**Your Ref: 2024/92576**  
**Our Ref: A004962**

**2nd December 2024**

**Site of Former Spotted Cow Pub, New Hey Road, Oakes, Huddersfield – Discharge of details reserved by condition 23 (surface water) of previous permission 2021/94029 for demolition of existing structures and erection of foodstore (class E) with associated access, parking, servicing areas and landscaping**

Client	LIDL GREAT BRITAIN Ltd				
Project	NEW HEY ROAD				
Title	DRAINAGE ARRANGEMENT SHEET 1 OF 2				
Drawing No.	16-3046-101	Revision	P5		
Scale	1:250 @ A1	Date	AUGUST 2024		
Drawn	GRE	Chk	App

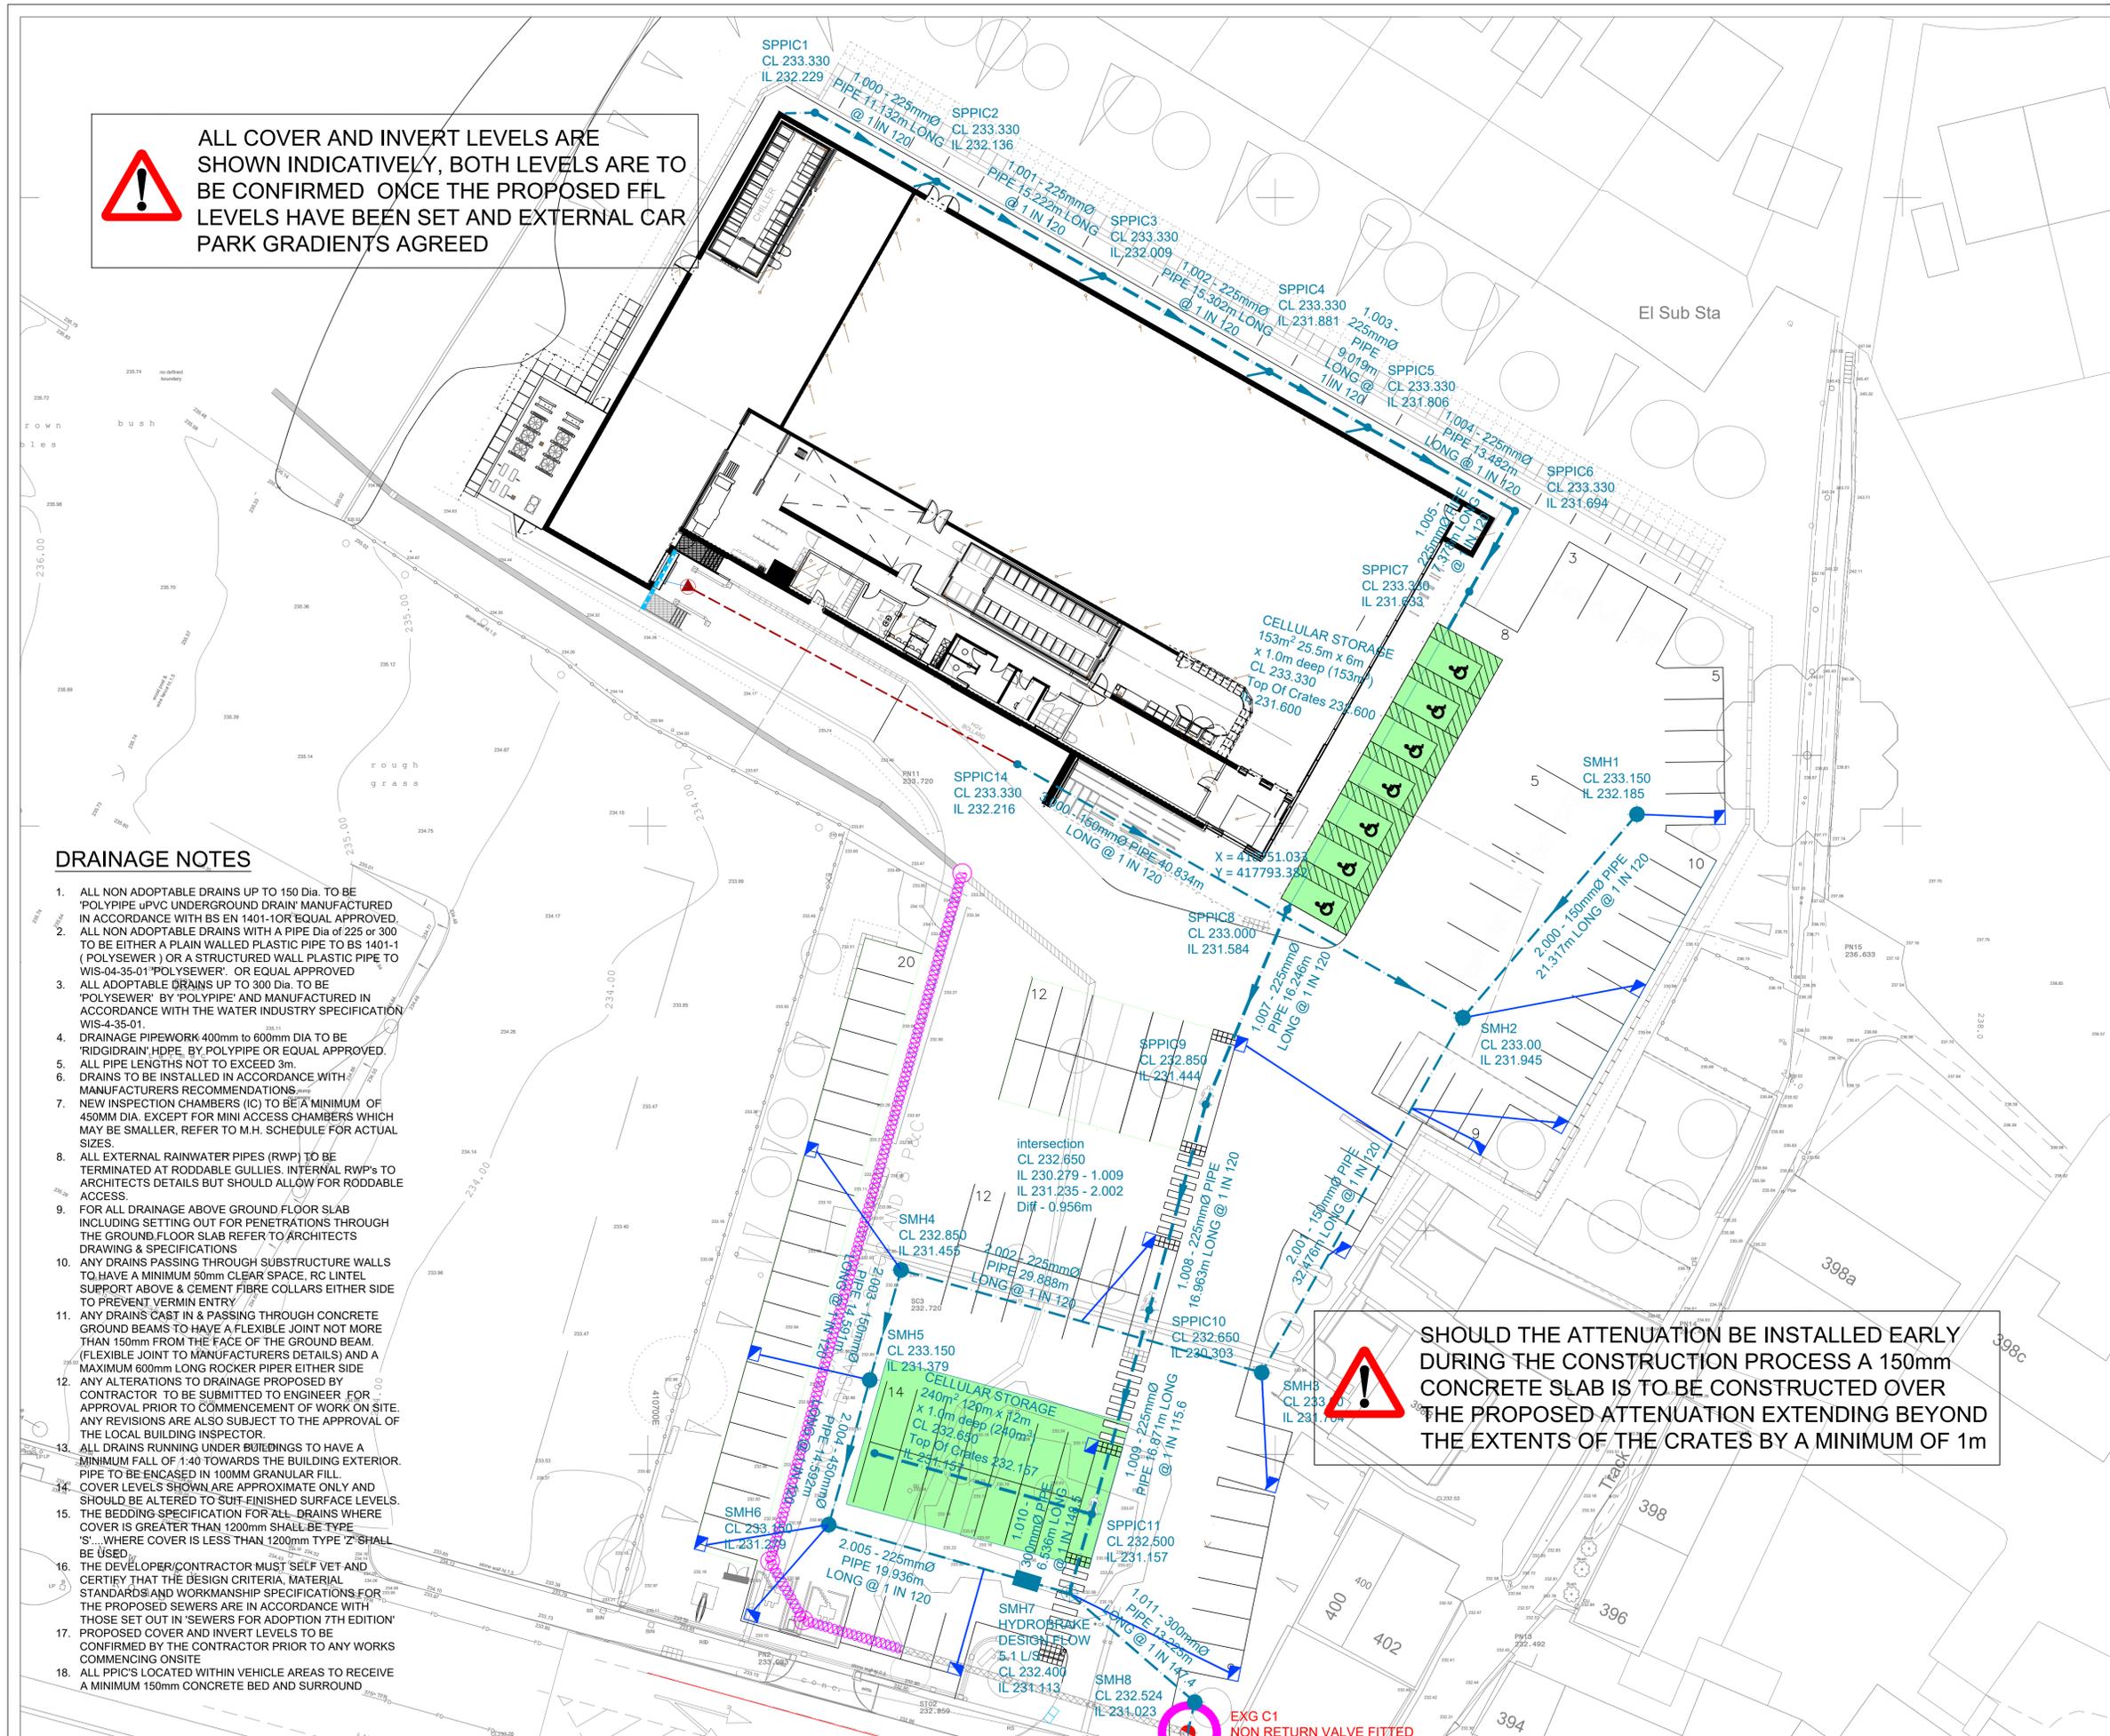
Yorkshire Water has no objection to discharge condition 23.

Yorkshire Water has no objection to:

- i) The proposed separate systems of drainage on site with combined off-site.
- ii) The proposed amount of domestic foul water to be discharged to the 225 mm diameter public combined water sewer located within New Hey Road.
- iii) The proposed amount of curtilage surface water to be discharged to the 225 mm diameter public combined water sewer network located within New Hey Road, at a restricted rate of 5.1 (five point one) litres/second.
- iv) The proposed point of discharge of foul and surface water to the public sewer network.

submitted on drawing, Drainage Arrangement Sheet 1 OF 2 16-3046-101 (revision P3) dated November 2024 prepared by Cora iHT.
